## WEST SUSSEX COUNTY COUNCIL CONSULTATION

<b>TO:</b>	Arun District Council FAO: K Welch
<b>FROM:</b>	WSSC – Highways Authority
<b>DATE:</b>	9 October 2025
<b>LOCATION:</b>	Pavement o/s Iceland 72-74 High Street Bognor Regis PO21 1SJ
<b>SUBJECT:</b>	BR/167/25/A Removal of existing BT Phone Kiosk and installation of 1 No new BT Street Hub, incorporating 2 No digital 1.905m internally illuminated LCD advert screens.
<b>DATE OF SITE VISIT:</b>	n/a
<b>RECOMMENDATION:</b>	Advice

This application is for the removal of existing BT phone kiosk and installation of one new BT Street Hub, incorporating two digital 1.905m internally illuminated LCD advert screens. The site is located on High Street, a C-classified road subject to a speed limit of 30mph.

Drawing Title
EXISTING AND PROPOSED
ELEVATIONS

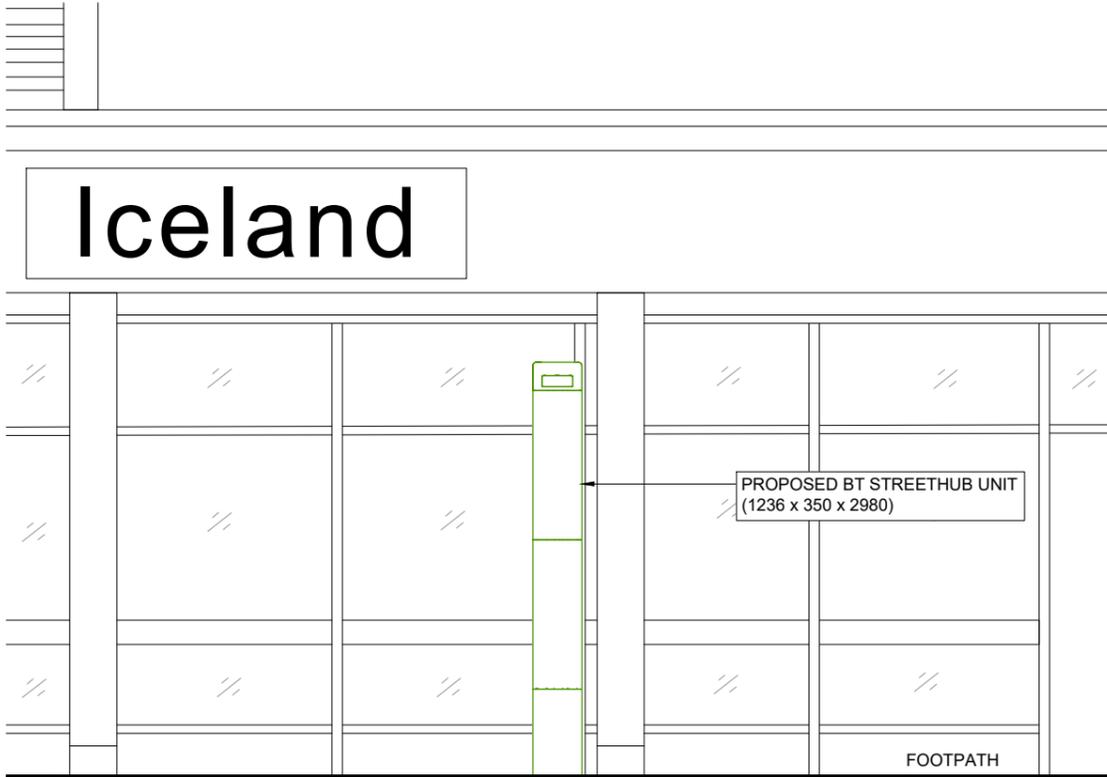
The proposed Street Hub will provide two digital 1.902m internally illuminated LCD advert screens. The Design and Access Statement indicates that the proposed advertisements will not contain moving images and changes between the advertisements will be instantaneous with no animated transitions. The maximum daytime luminance level would be 5000cd/m<sup>2</sup>. The Design and Access Statement indicates that the applicant would be agreeable to a condition restricting the BT Street Hub to a maximum luminance level of 600cd/m<sup>2</sup> in the hours of darkness; however, in accordance with Table 10.4 of The Institute of Lighting Engineers' Professional Lighting Guide 05/23 "The Brightness of Illuminated Advertisements including Digital Displays" (2023), the maximum luminance level for an advertisement within the E4 environmental zone is 300cd/m<sup>2</sup>.

Whilst the LHA would not raise any highway safety concerns to the principle of the proposed BT Street Hub, we would request that the applicant reduce the proposed luminance level within the hours of darkness to accord with the maximum luminance level for the location's environmental zone. The LHA consider that this could be dealt with via condition, however the LPA may wish to resolve this matter prior to determination.

2. The intensity of the illumination of the signs shall not exceed 300cd/sqm during the hours of darkness.

3. The intensity of the illumination of the signs shall not exceed 5000cd/sqm during daylight hours.
